PLANNING DEPARTMENT – Development Review Services

June 1, 2015

**RE: Los Diamantes Subdivision  
Drainage Report, and Grading and Drainage Plan  
Engineer's Stamp Date 3-24-2015 (File: N09D013)**

LOS DIAMANTES SUBDIVISION STREET CAPACITY EXHIBIT

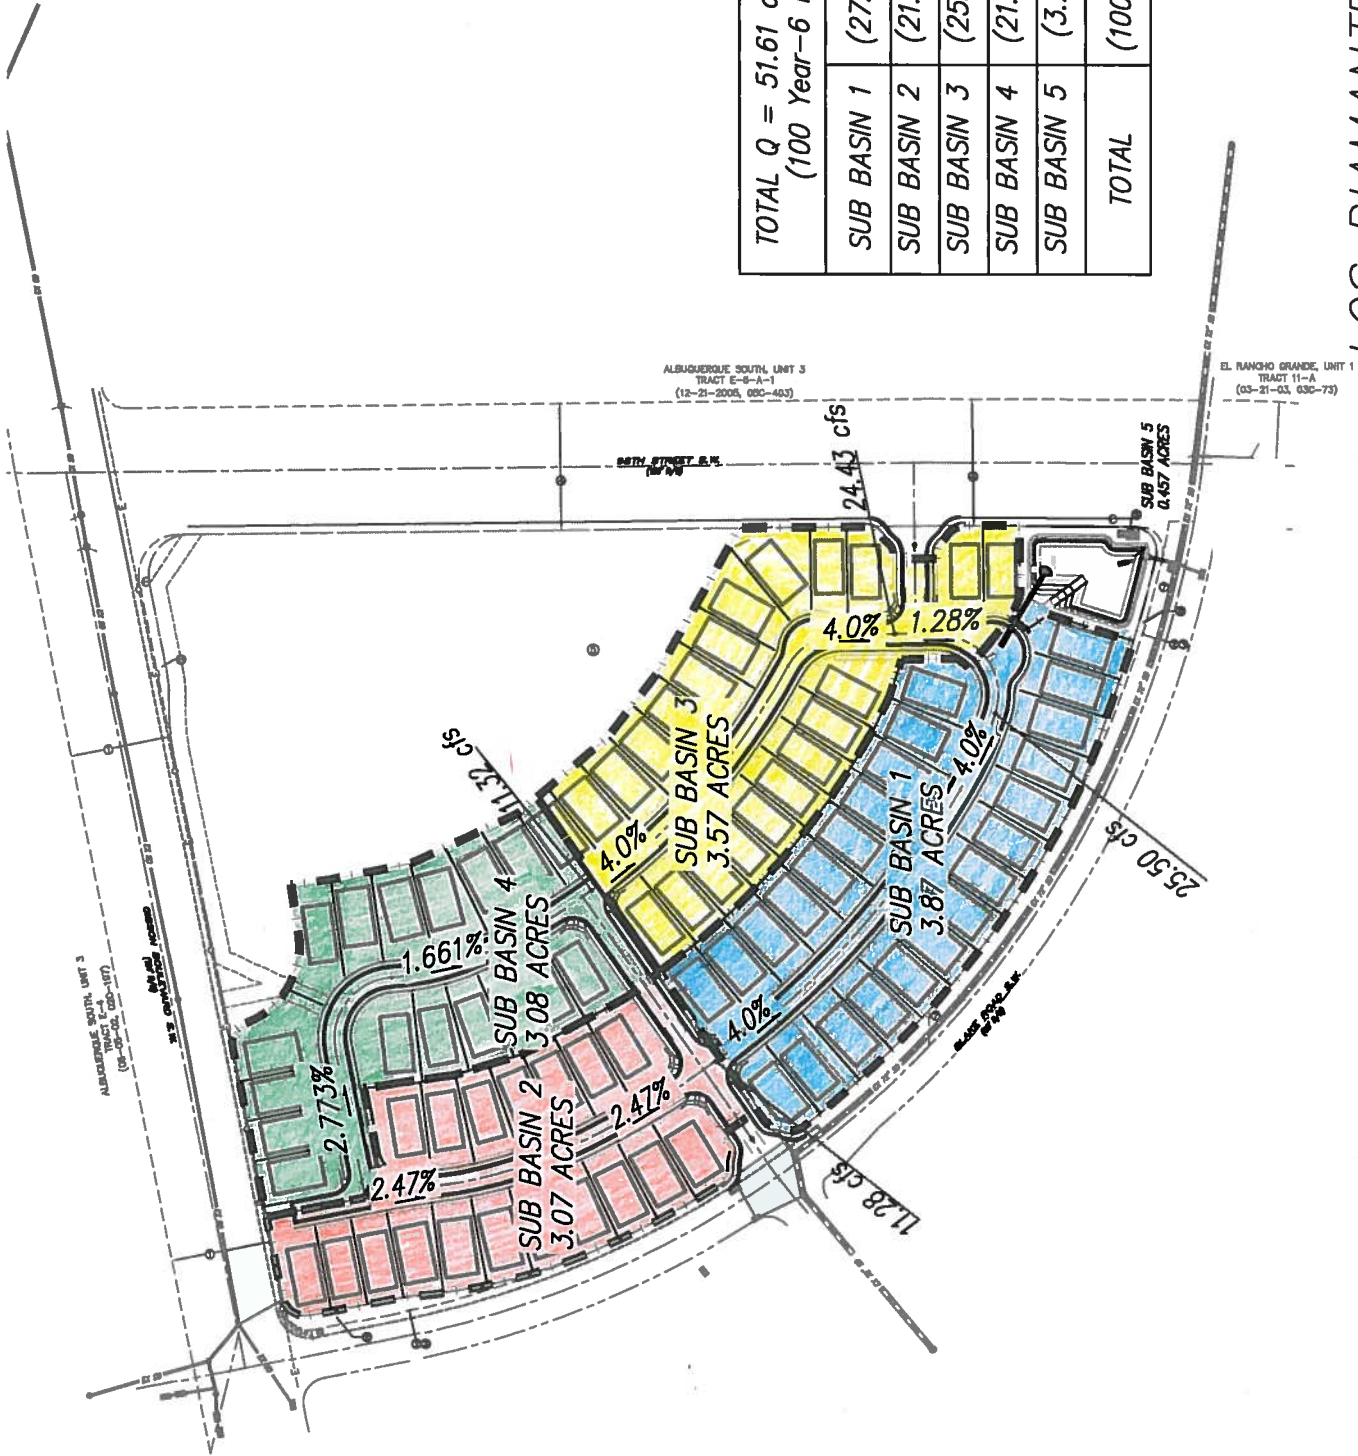
2. It is acceptable to discharge more than the intended 33 cfs into the 30" stub. How is the discharge part of the rating curb calculated in AHYMO? Also show that the 72" SD between MH 16 and 17 has capacity.
3. The grated inlet in Gold dust way Cul-de-sac is not a COA standard. Provide standard inlets.
4. Show Pond Volume on the Plan.
5. If Tract A is intended to discharge into 98<sup>th</sup> St. in the undeveloped condition, a desilting pond should be shown on the grading plan. Contours show that the SE corner of Tract A is at same elevation as T.O. Curb but view from google earth shows it to be lower than T.O. Curb in that area. Please confirm survey is accurate.

Basin Boundary -
Sun Gate Estates
EXHIBIT 4

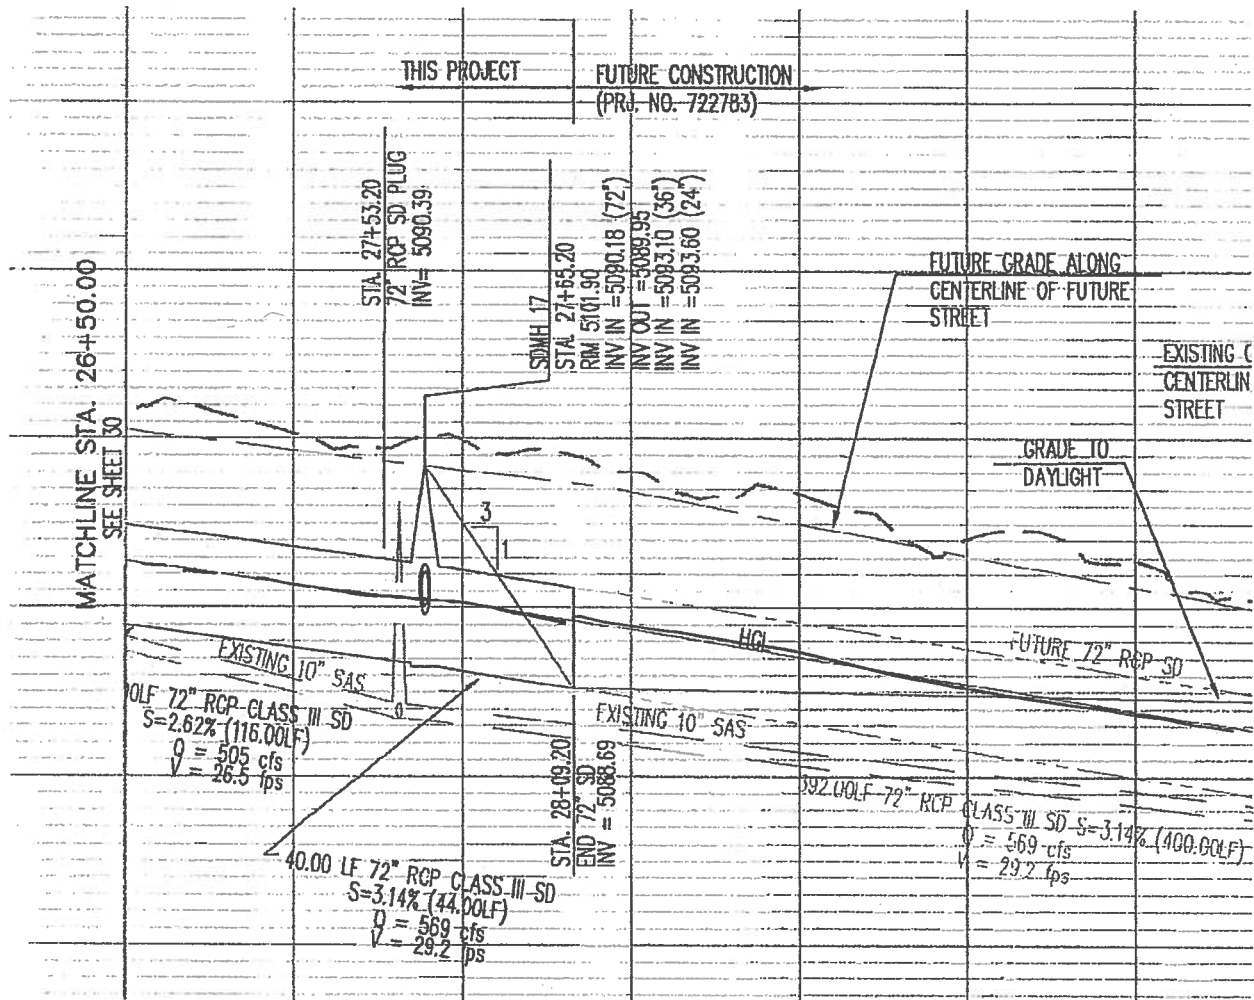
- Per the meeting notes dated 3-11-15, the allowable discharge into the 30" stub at SDMH 16 (CPN 736782) is the difference between the upstream and downstream Q, or  $505\text{cfs} - 472\text{cfs} = 33\text{ cfs}$ . This value matches that shown on Exhibit 4, Master SD Basin Map, for basin DB16.
- Per the same meeting notes, the Q at 98<sup>th</sup> St. is noted as 569cfs. The difference between the upstream and downstream Q at MH 17 is  $569\text{cfs} - 505\text{cfs} = 64\text{cfs}$ . Exhibit 4 shows that DB20 (the roadway) discharges 19cfs, so 45 cfs is the allowable from DB9 (Exhibit 4).
- Per meeting notes, a storm drain in 98<sup>th</sup> was required.
- During the meeting we agreed that the street flows in Blake could be ignored due to the timing of the hydrograph.
